# Gatwick Northern Runway Development Consent Order Application TR020005

Reigate & Banstead Borough Council 20044474

Principle Areas of Disagreement Summary Statement (PADSS)  
Version 3 Deadline 5 Submission Tracked Changes Version

6<sup>th</sup> June 2024

Figure 1. Reptile Trapping Area A and Receptor Site

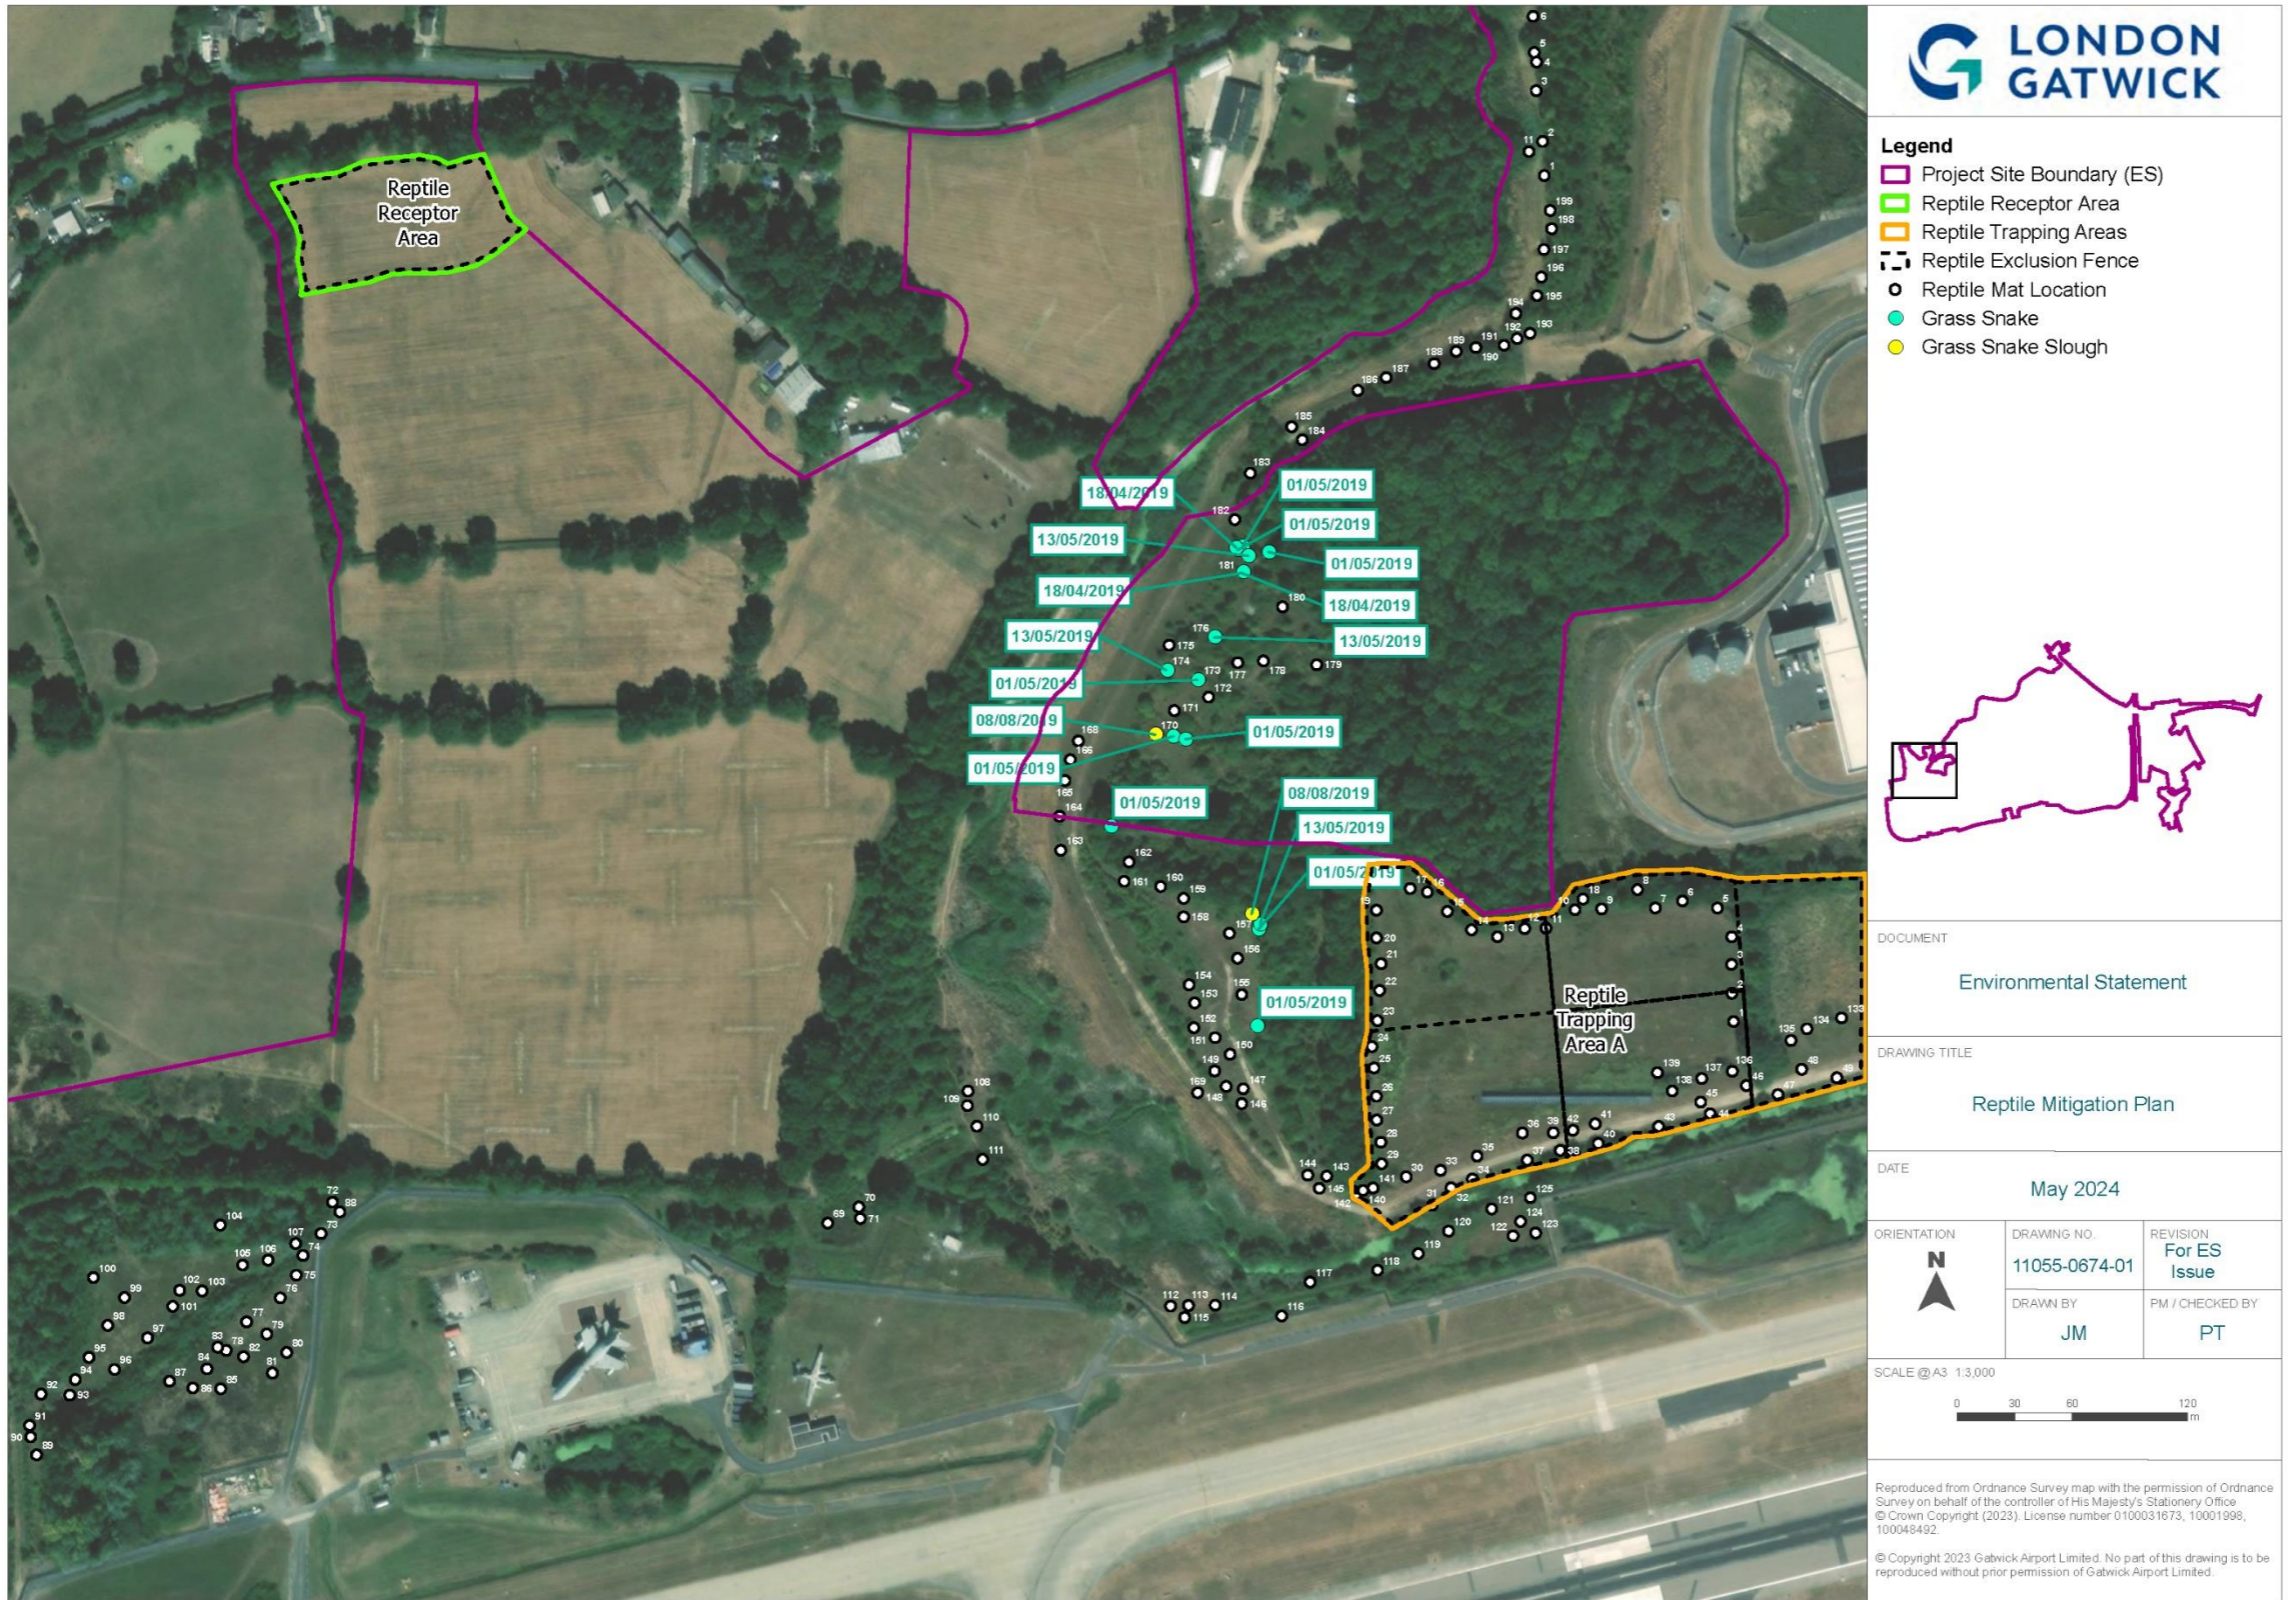
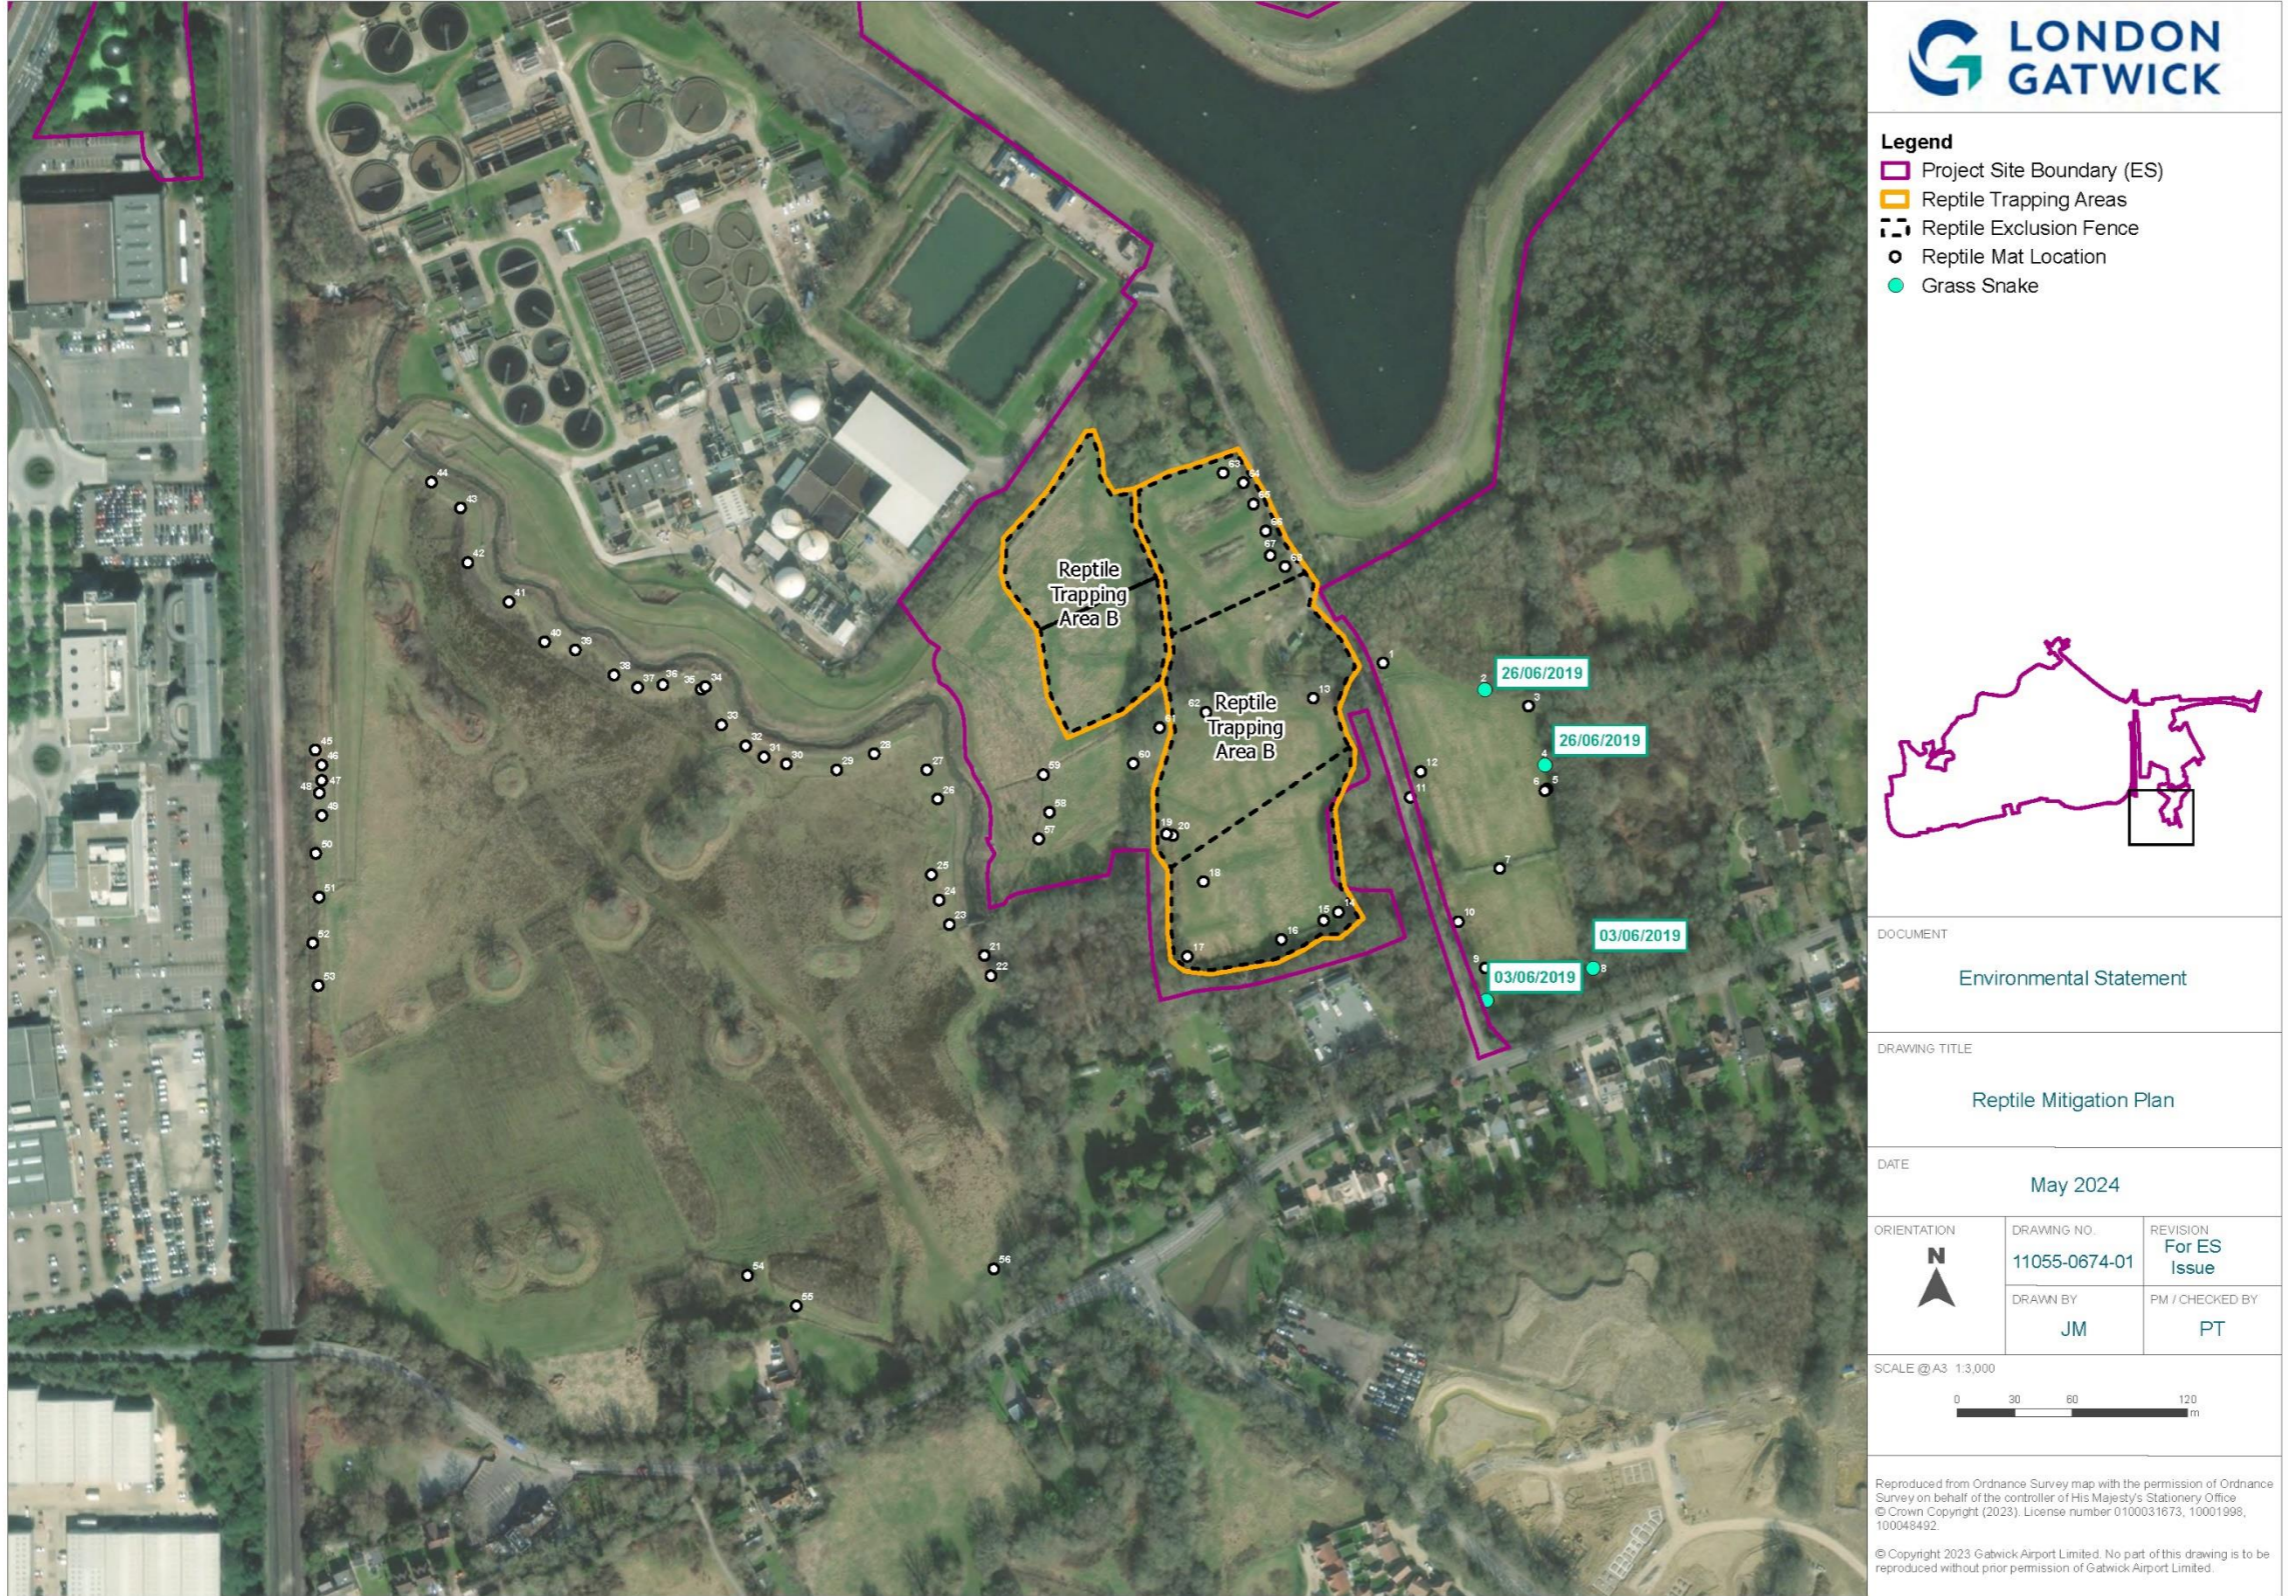
11.	Lack of information on reptile and great crested newt (GCN) mitigation	<p>The ecology chapter for the ES states that reptile and GCN mitigation will involve translocation to receptor sites and where relevant, European Protected Species Licences would be applied for post DCO consent. However, no detailed information is provided for the reptile and GCN mitigation strategy, for example:</p> <ul style="list-style-type: none"> <li>• Where are the receptor sites? Reference is made to Longbridge Roundabout, Museum fields and other mitigation areas but there is no detail as to which one of these has been chosen to be the receptor locations for reptiles and GCN.</li> <li>• No methodology or timings information for the mitigation strategies.</li> </ul> <p>Whilst it is appreciated that this is outline consent, an outline mitigation strategy is still required for reptiles and GCN.</p>	<p>Additional information has been provided in the Applicant's SoCG response. This should be included within the submission documentation. It remains unclear whether residual impacts have been assessed appropriately without having an outline mitigation strategy in place.</p> <p><u>Updated position (Deadline 5): It is standard practice for an outline mitigation strategy to be submitted prior to planning approval. Whilst we appreciate the finer detail will come later, a high level overview is required so as to be satisfied that the 'favourable</u></p>	Likely

<u>conservation status' of the population will be maintained. We will review the Deadline 5 submission.</u>	
12.	No compensation provided for loss of ponds	The ecology chapter states that no replacement ponds will be provided within the application site due to airport airstrike safety. This is fully justified however, it is not understood why off-site provision of new ponds has not been considered.	<p>It remains unclear why replacement ponds could not be provided off-site – preferable within the nearby Biodiversity Opportunity Areas to maximise ecological opportunities / outcomes.</p> <p><u>Updated position (Deadline 5): We understand the reasoning as to why ponds are not being provided on site (bird strike risk), however, to date, we are still unclear why the provision of off-site ponds has not been considered / explored?</u></p>	<del>Uncertain</del> <u>Unlikely</u>
